CITY OF ALBUQUERQUE

July 15, 2024

**Re: Unser Crossing
8400 Central Ave. SW
Conceptual Traffic Circulation Layout for DFT Approval
Architect's Stamp 06-14-24 (K10-D045C)**

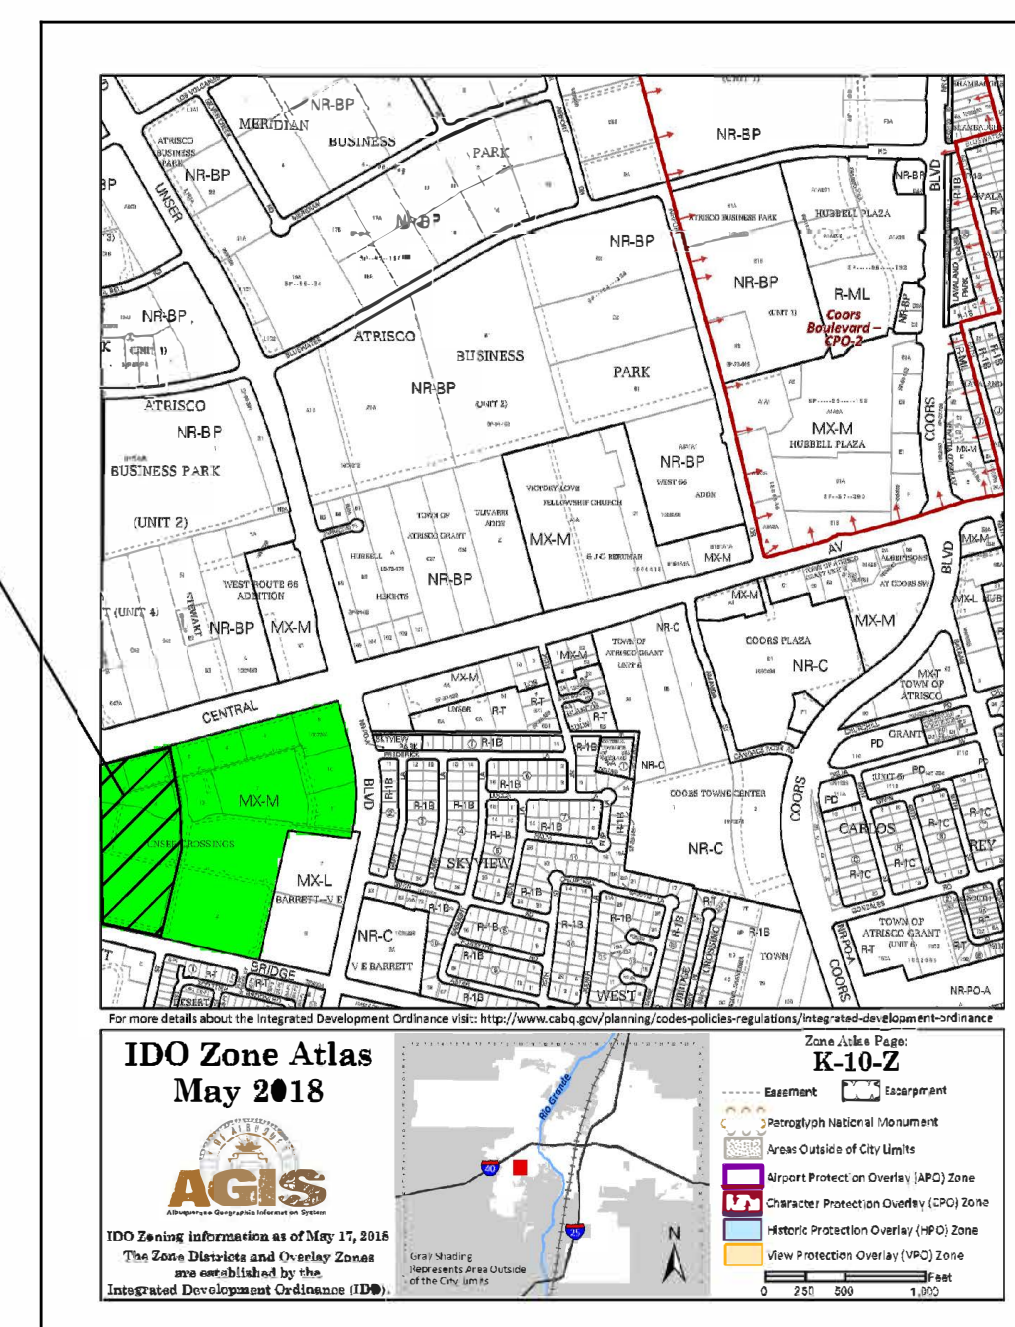
- **An approved plat must be provided.**
- **Identify the right of way name and width on Bridge blvd. and 86th St.**
- **The minimum distance from the intersection of Bridge Blvd and 86th St. to site access off the 86th st. should be 100 ft. Please show this dimension on the site plan.**
- **The minimum distance from the intersection of Central Ave. and Victory Ln to site access off Central should be 150 ft. Please show this distance on the site plan.**
- **Keynote 4: Please provide 6 ft wide ADA pathway from the public sidewalk to the building entrance.**
- **Keynote 26: revocable permit is required for any private signs located within public right of way.**
